From:
Sent: 11 March 2026 11:22
To: DC Admin
Subject: Planning Application 2025/90033 - Erection of 11 dwellings adj 916 Halifax Road - additional part 2

With reference to my earlier emails of 09/03/26 I write with supplementary information to support my **objection** to the above proposed development.

DRAWING TITLE
Proposed Plots 3 and 4

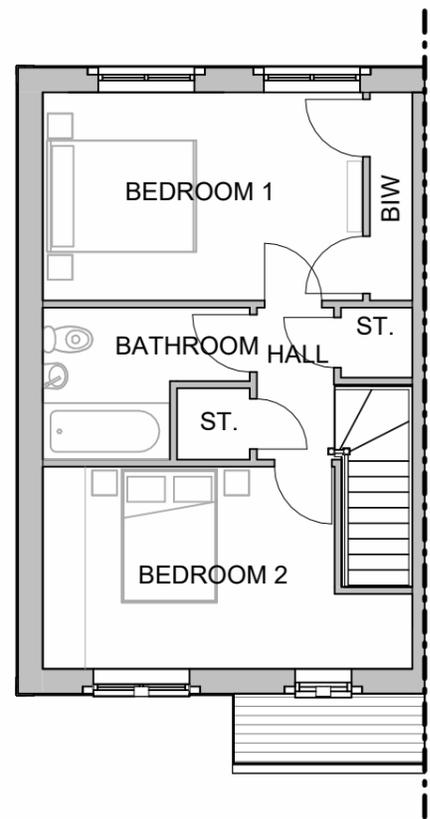
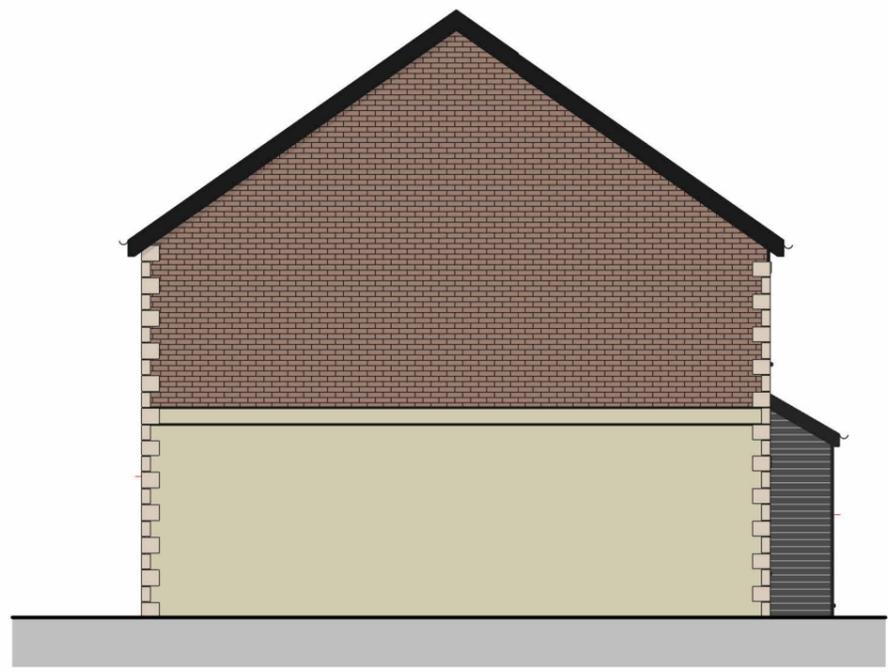
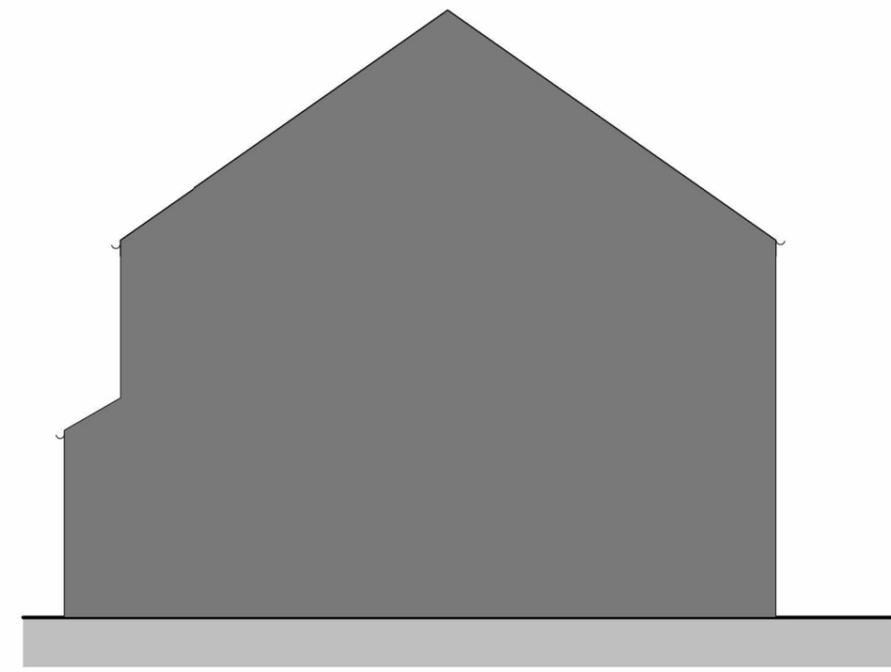
I've also been able to determine the distance between our living room window and that of the living kitchen windows in Plots 3 and 4. The measuring tool suggests the proposed distance is 12.75m, where I believe the minimum requirement to be 21m.

In addition, I understand there is a minimum requirement of 11m for garden privacy where first floor windows overlook neighbouring gardens. The distance between the first floor rear windows of Plot 3 is around 7.6m and Plot 4 is around 8m.

Plots 2, 3 and 4 are simply too close to our property, and I urge you to reject the application on this basis.
